Re: 303 Auburn Street – 379-F-021 - R-3 Residential Zone

I am in receipt of your request for a determination letter to determine whether a separate lot can be split off the rear of the existing lot at 303 Auburn Street that will meet the requirements of the underlying zone. This lot is located in the R-3 Residential Zone. My determination is based upon a signed and sealed survey performed by David L. J. Hughes, PLS and dated March 26, 2015 and called "Plan Showing Proposed Division at 303 Auburn Street".

PLAN SHOWING PROPOSED DIVISION
AT 303 AUBURN STREET
PORTLAND, MAINE
MADE FOR
LINDSAY AND TYLER HOLDEN

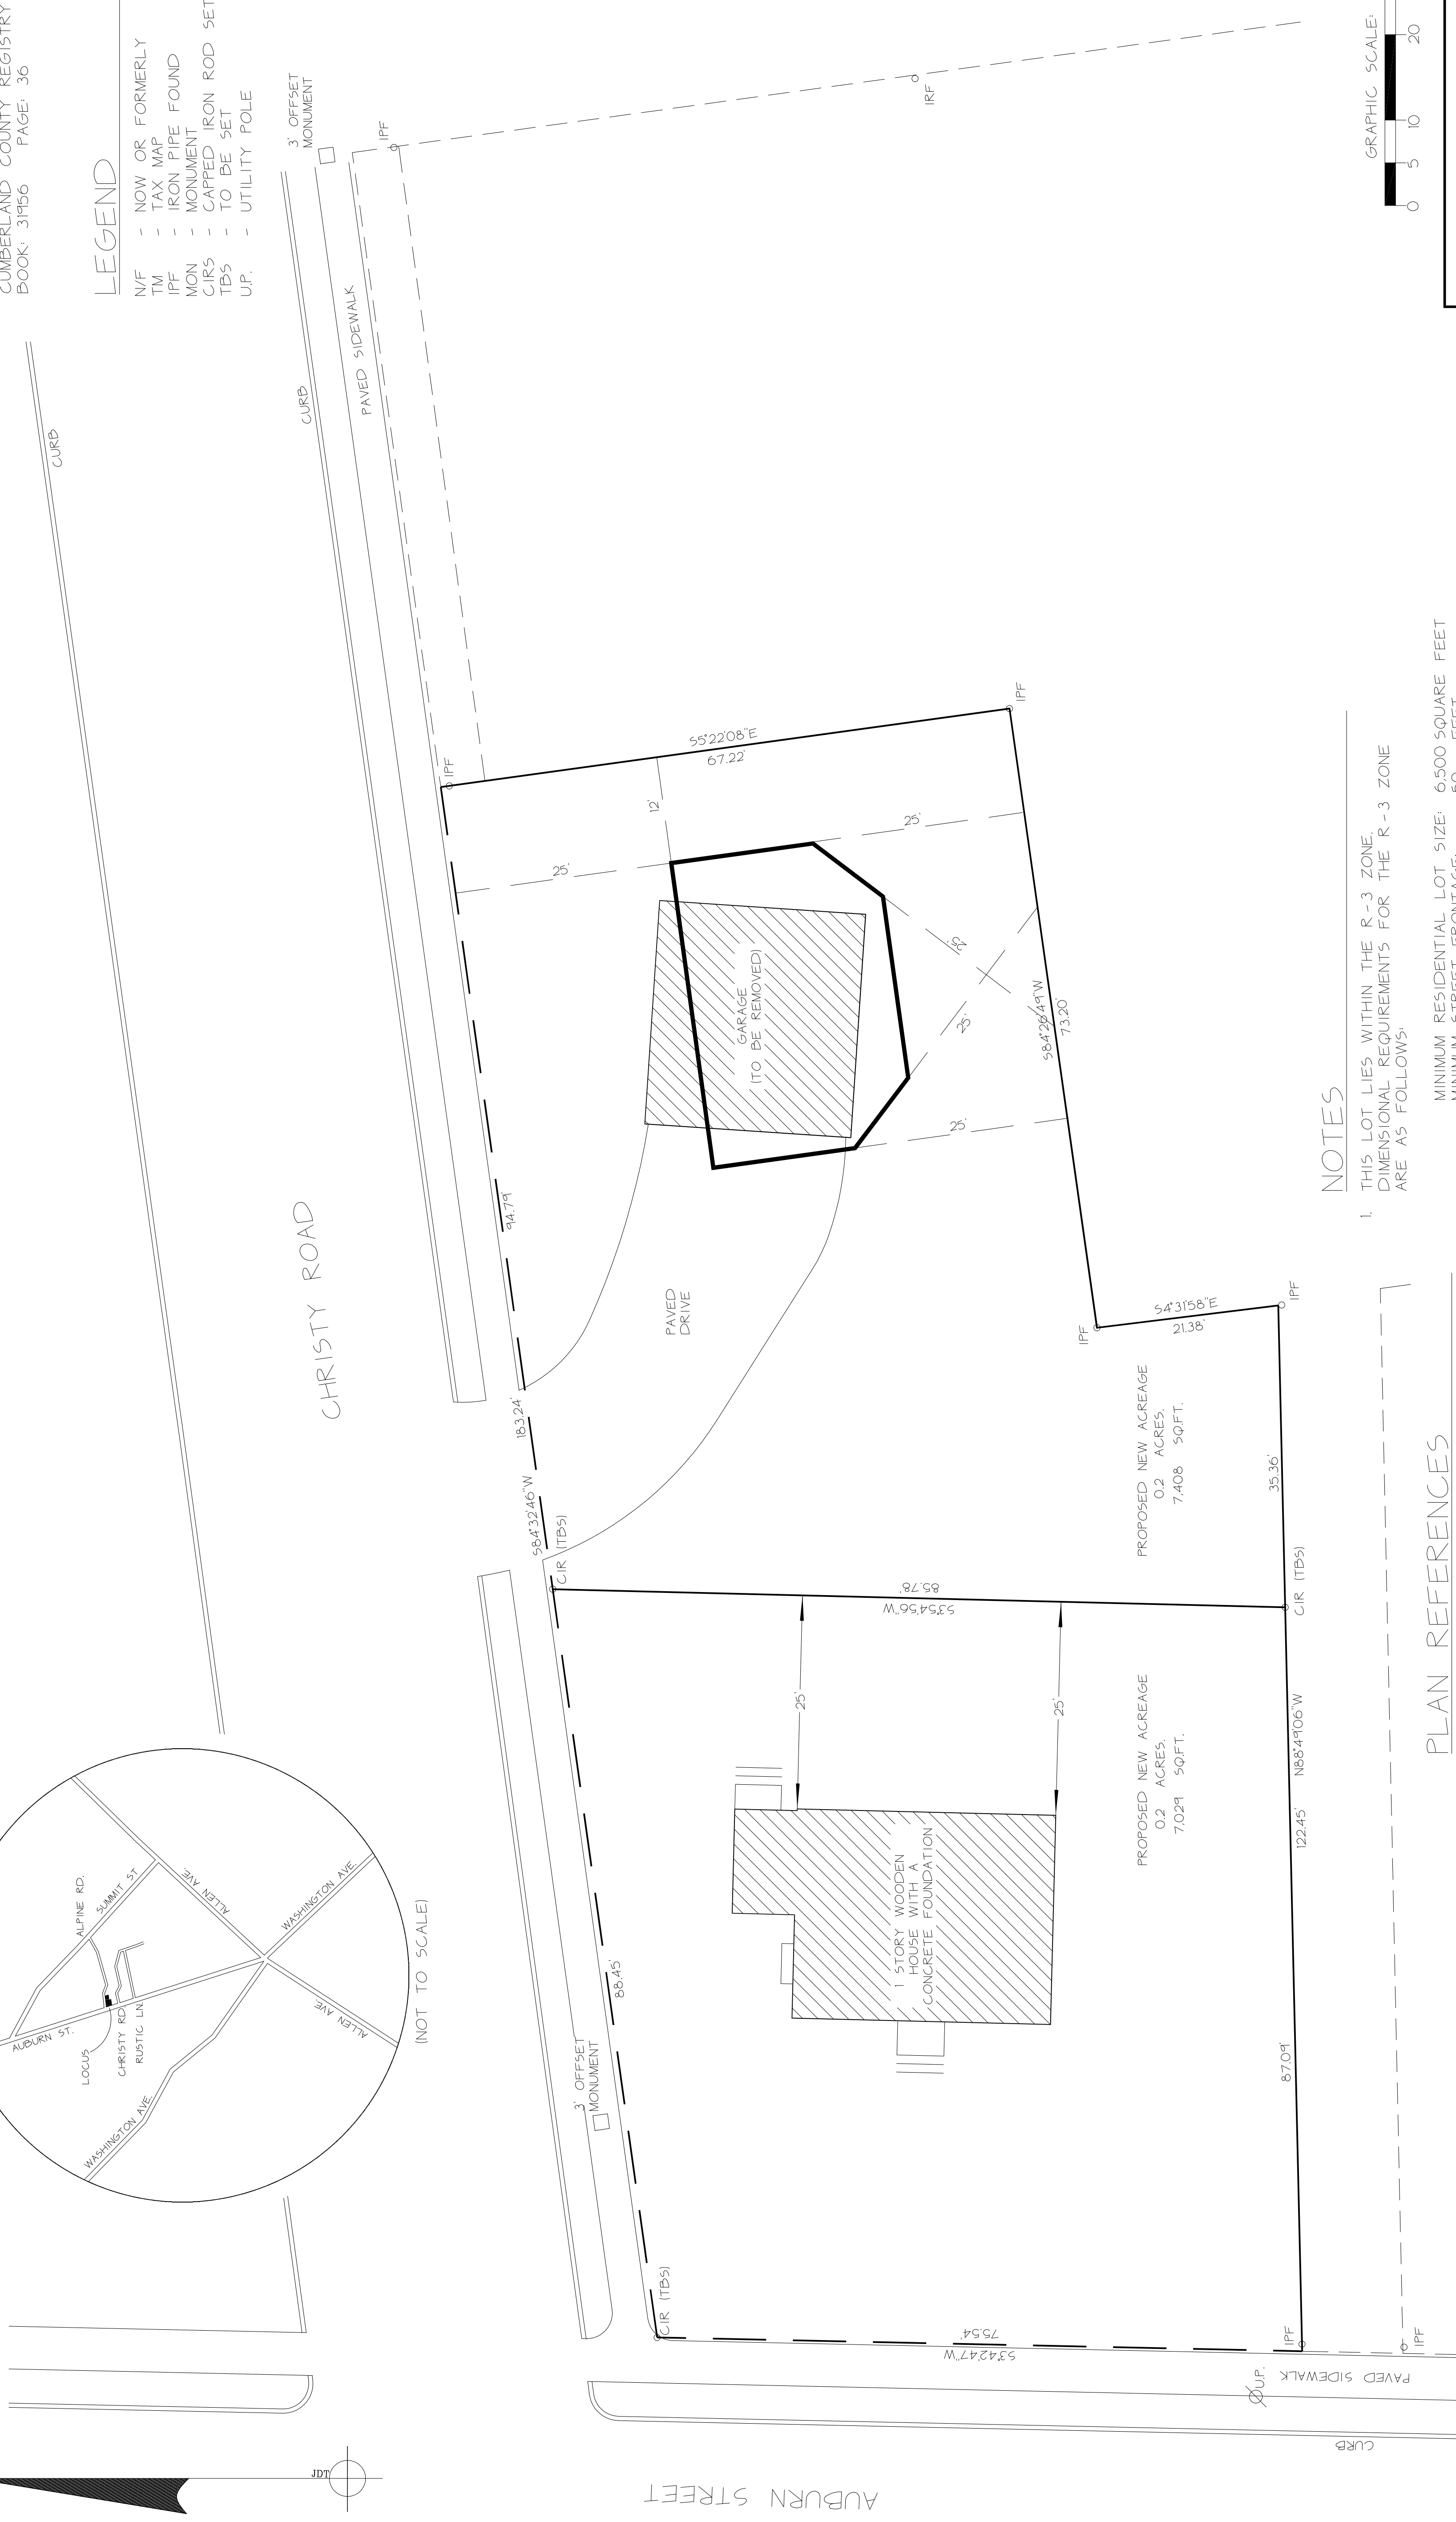
Based upon the submitted survey, the proposed lot at the rear of the existing lot with frontage on Christy Road is meeting or can meet, when it is built upon, all the R-3 dimensional requirements. Please note that in order to develop the lot, the existing garage will have to be removed. Also the dark "hexagon" shape shown on the survey over the existing garage does not indicate a buildable footprint. As shown on the survey, the remaining developed lot is also in conformance with the R-3 dimensional requirements. Please keep in mind, that with the proposed lot split, the existing lot at 303 Auburn Street will have to have two off-street parking spaces located on the lot.
